92 West S

Reviewed for Code Compliance
Inspections Division
Approved with Conditions
Date: 11/07/16

STAIRS
FROM 2ND
Floor LNDG
TO
3RD Floor

# 2<sup>ND</sup> FLOOR

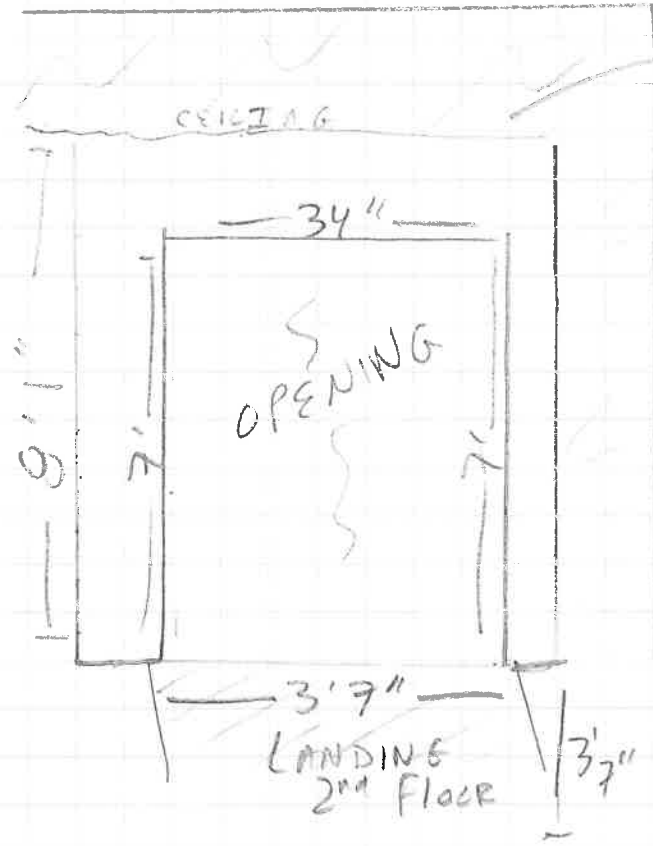
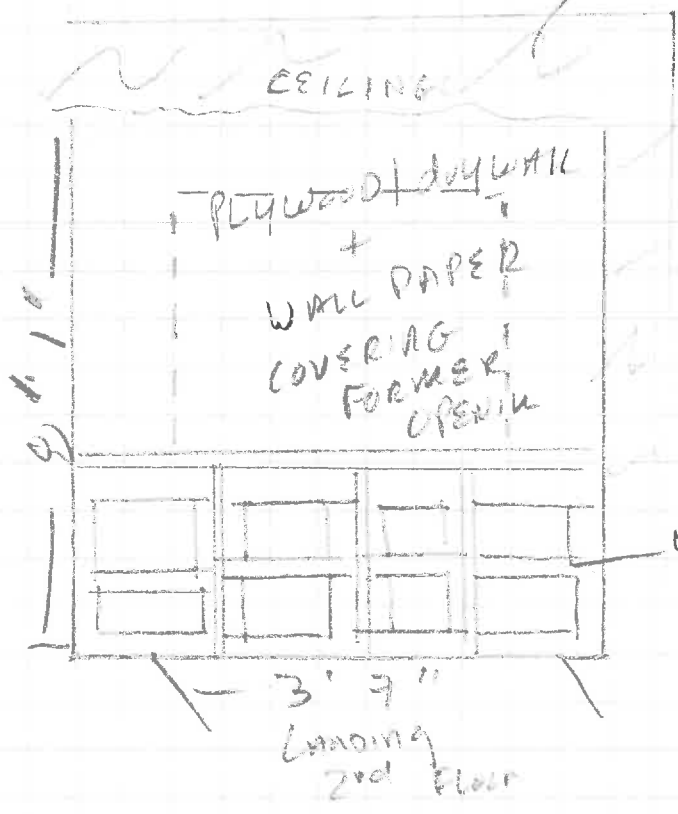
Applicant confirmed 2x4
framed wall infill of
pre-existing stair opening
